**From:** Lindsey Ozbolt  
**Sent:** Tuesday, May 01, 2018 12:26 PM  
**To:** 'Chad Bala'  
**Subject:** RE: Dunford & palomino div 1 correction

In regards to Palomino Plat Division 1 final mylar to correct scrivener errors, Public Works has reviewed and finds that it meets all Public Works requirements. Planning Division has also reviewed and finds that the wetland boundary has been provided on the face of the plat as required by preliminary approval condition. Since this is a re-plat only to correct scrivener errors, the Title/Name on the plat shall remain "Palomino Fields Plat - Division 1". To address that this is a scrivener error correction, please add the following note under General Notes:

A Portion of the NE 1/4 of the NW 1/4 of Section 27, Township 18 North, Range 18 East, W.M.  
 Palomino Fields Plat - Division I  
 Kittitas County Washington

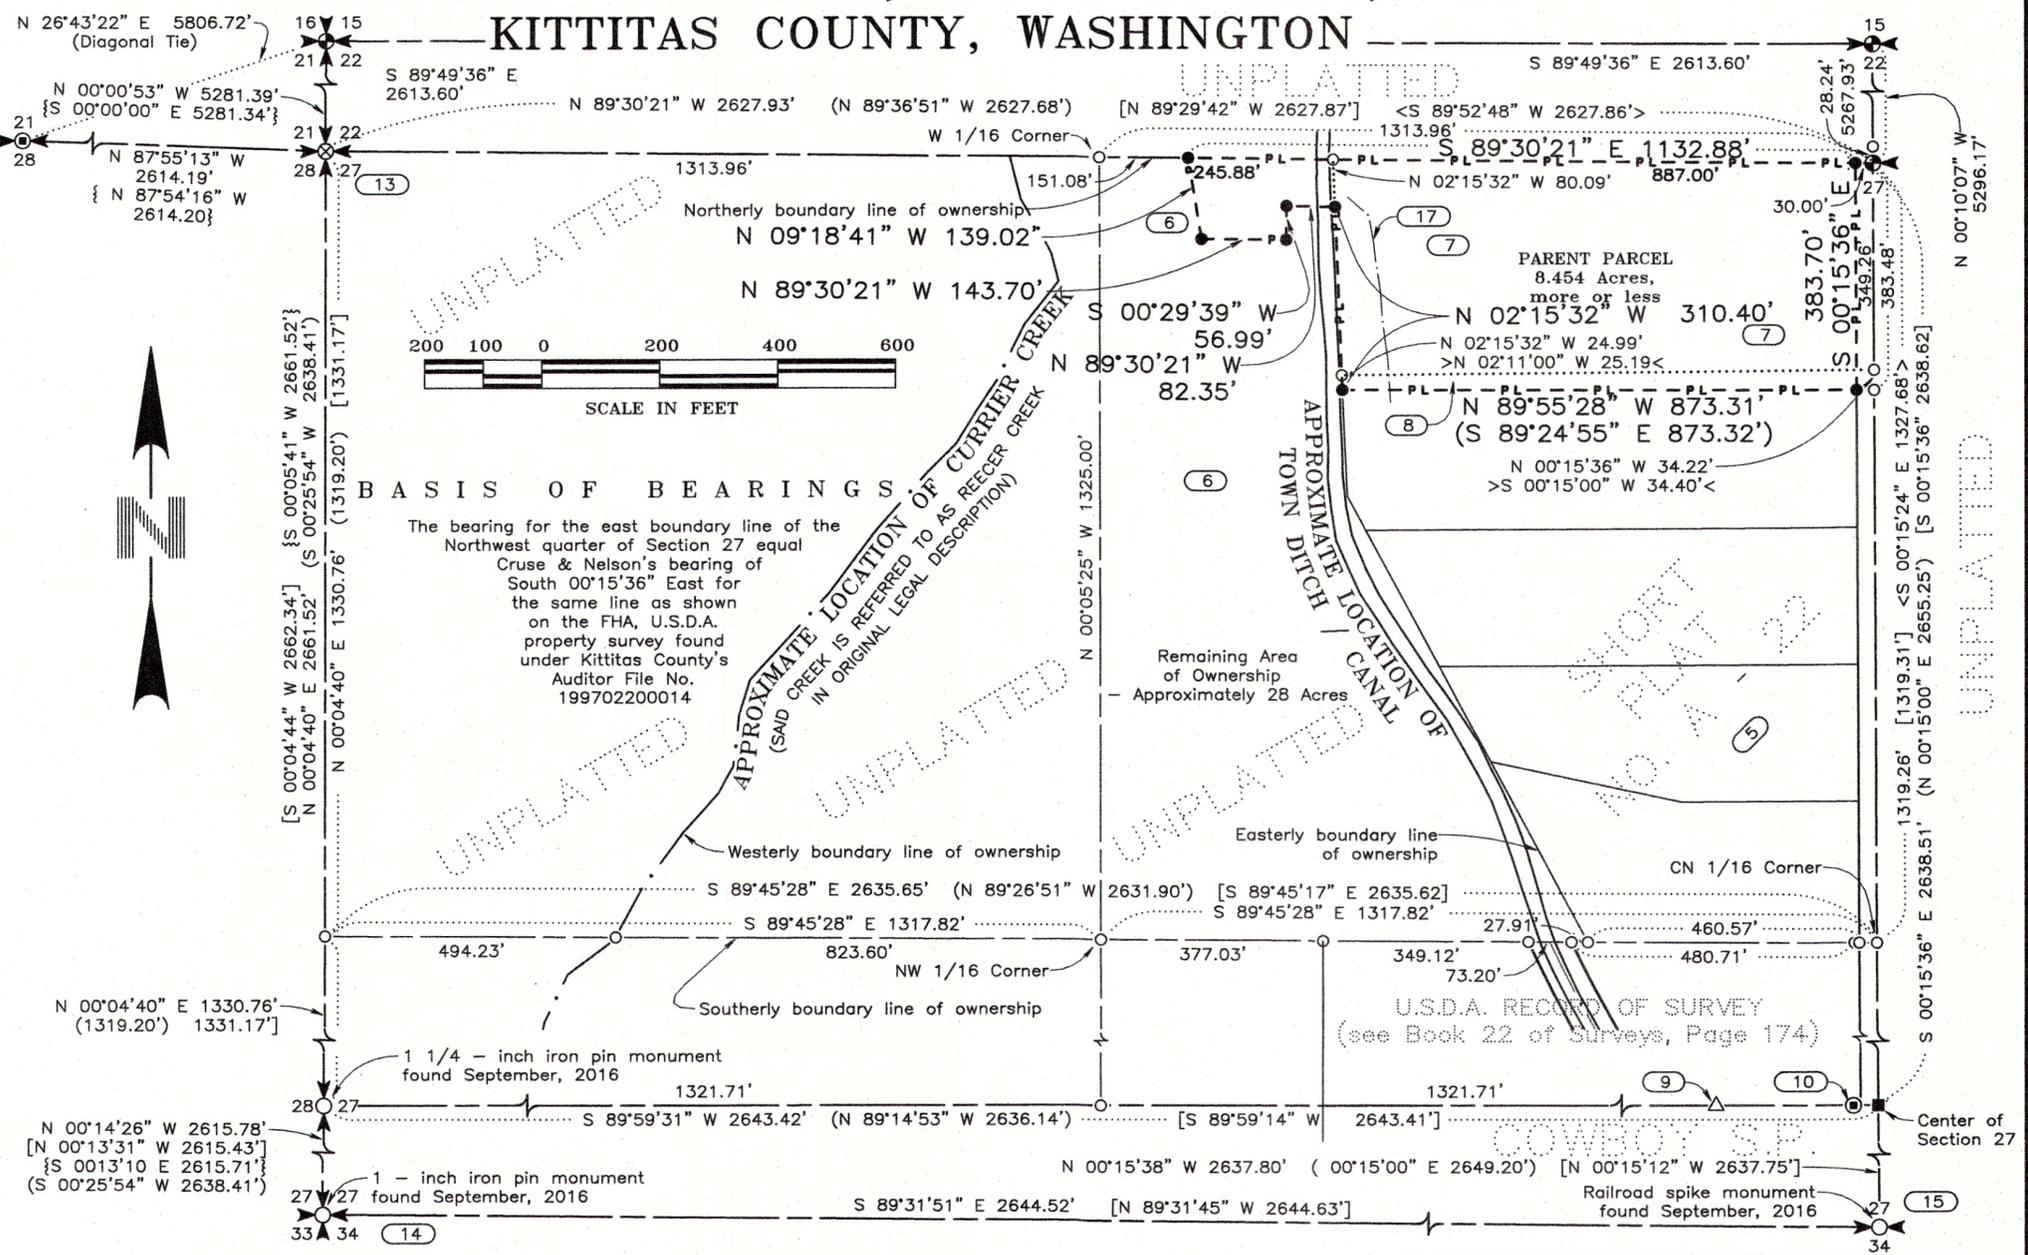
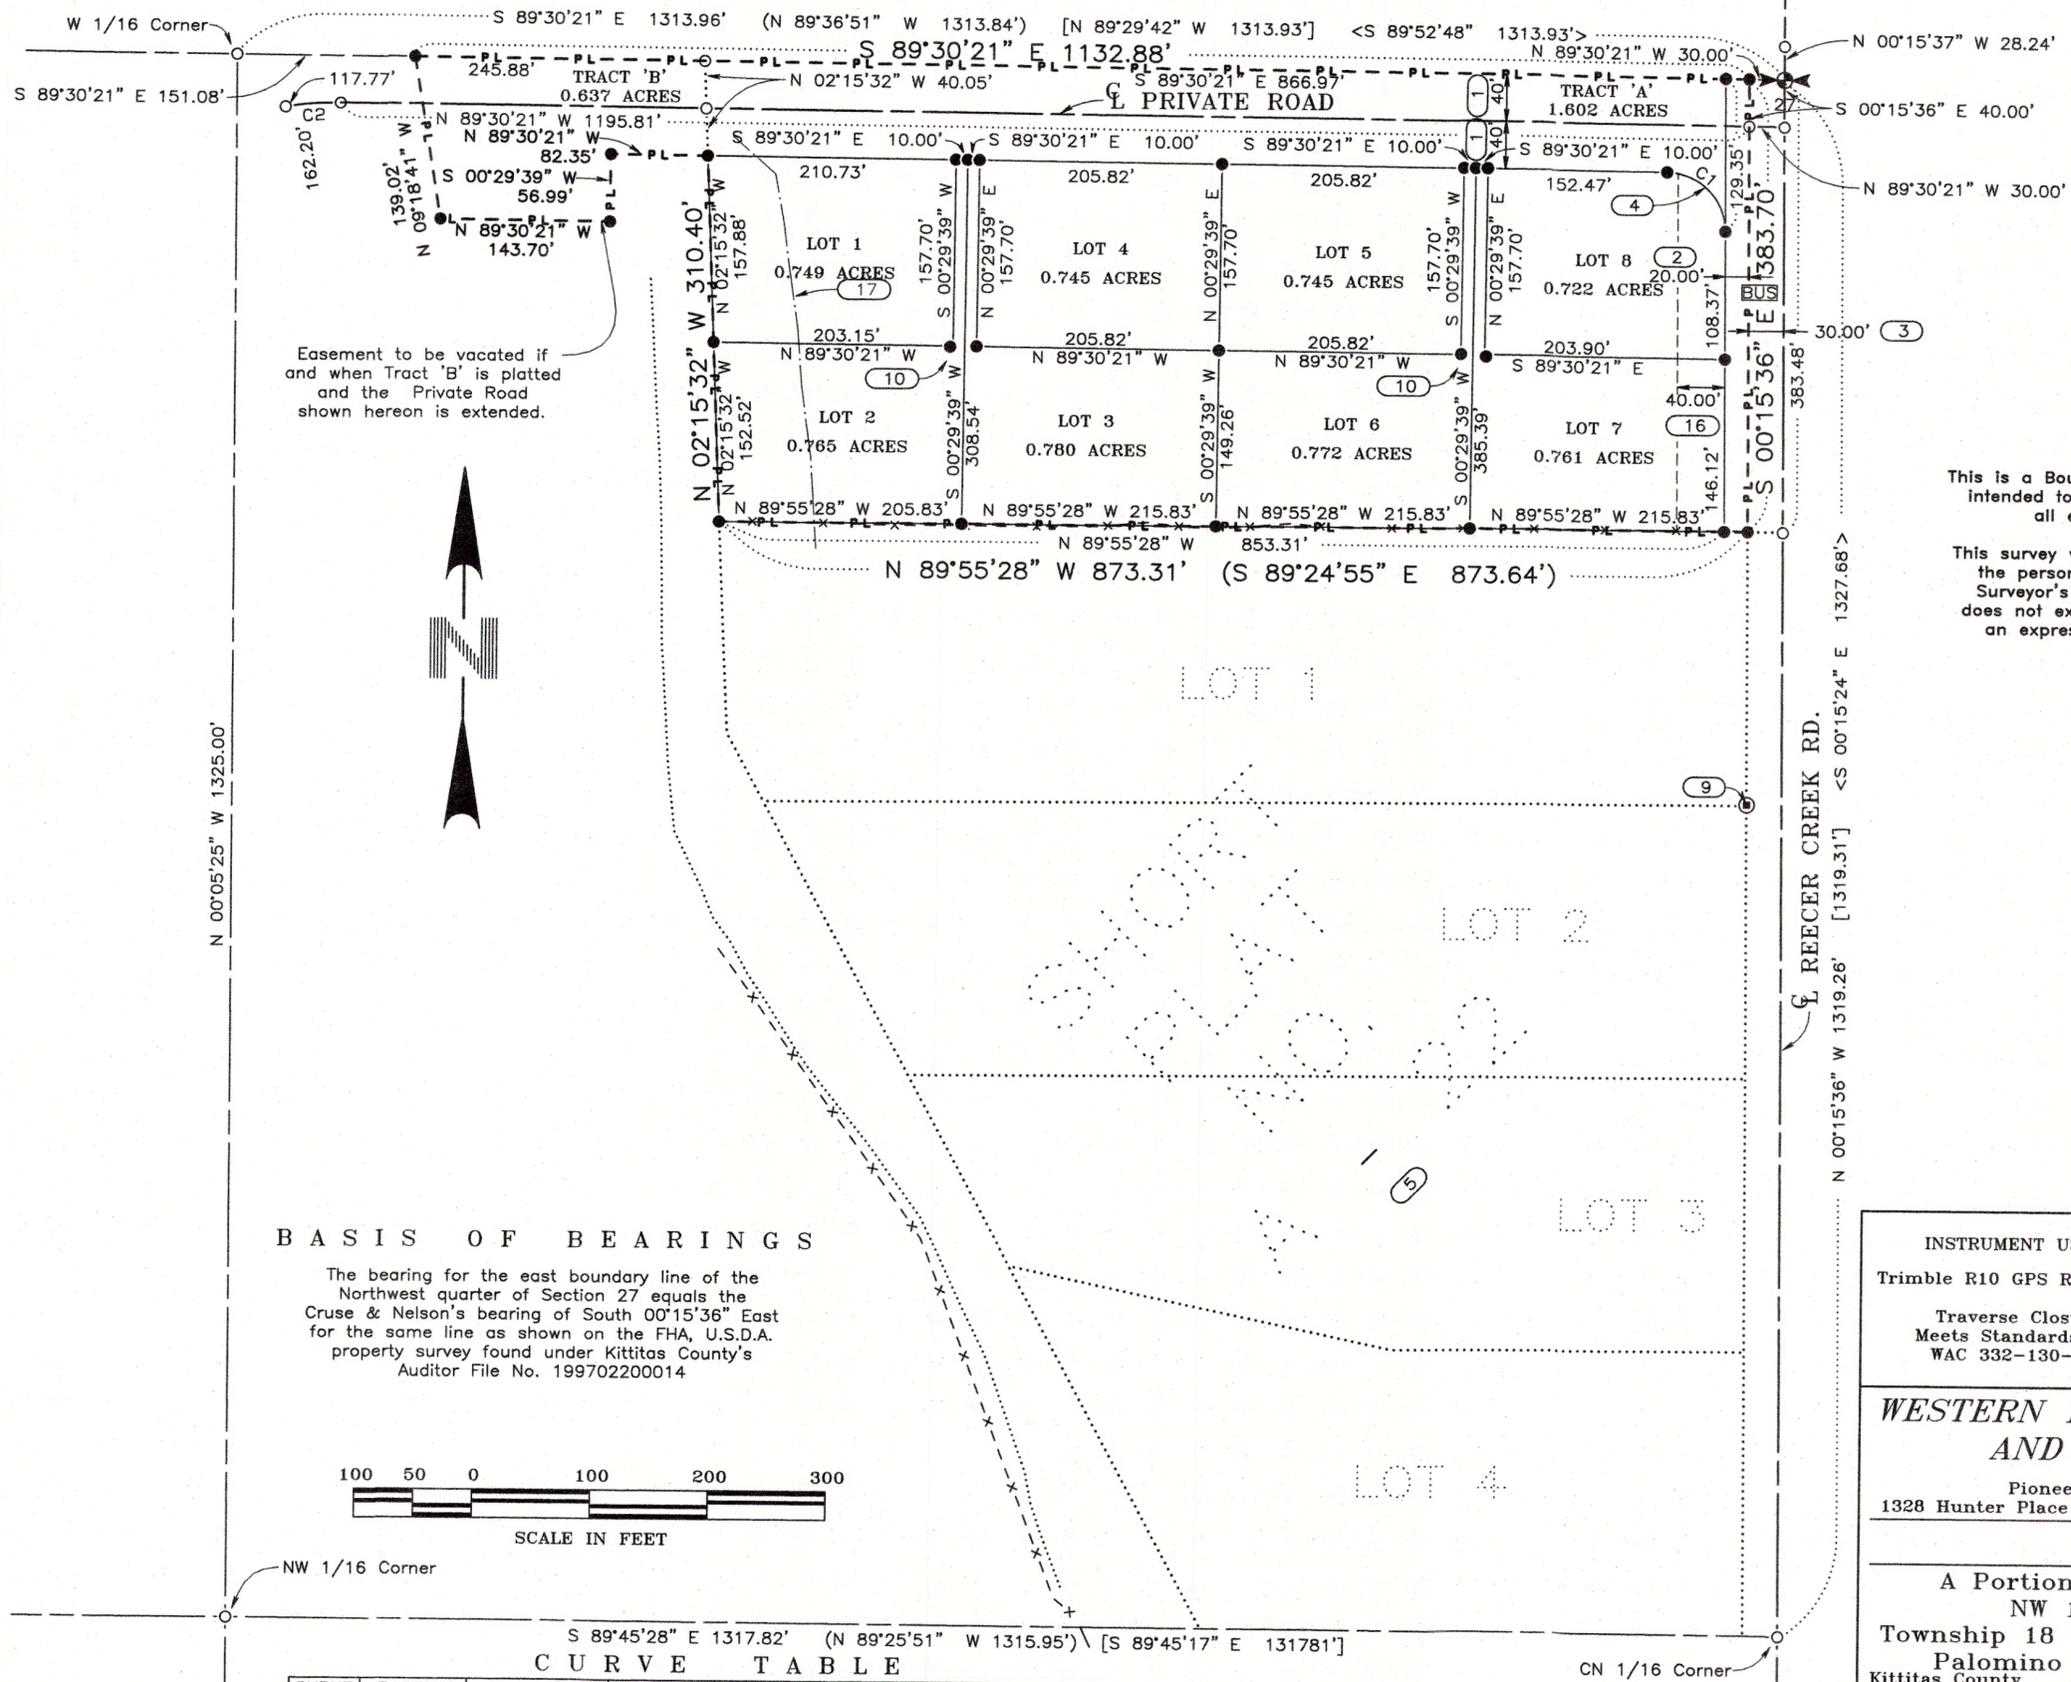
"The Palomino Fields Division 1 plat was originally recorded under Receiving No. 201708150006. This plat division is being recorded again to correct scrivener errors that were discovered after the original recording."
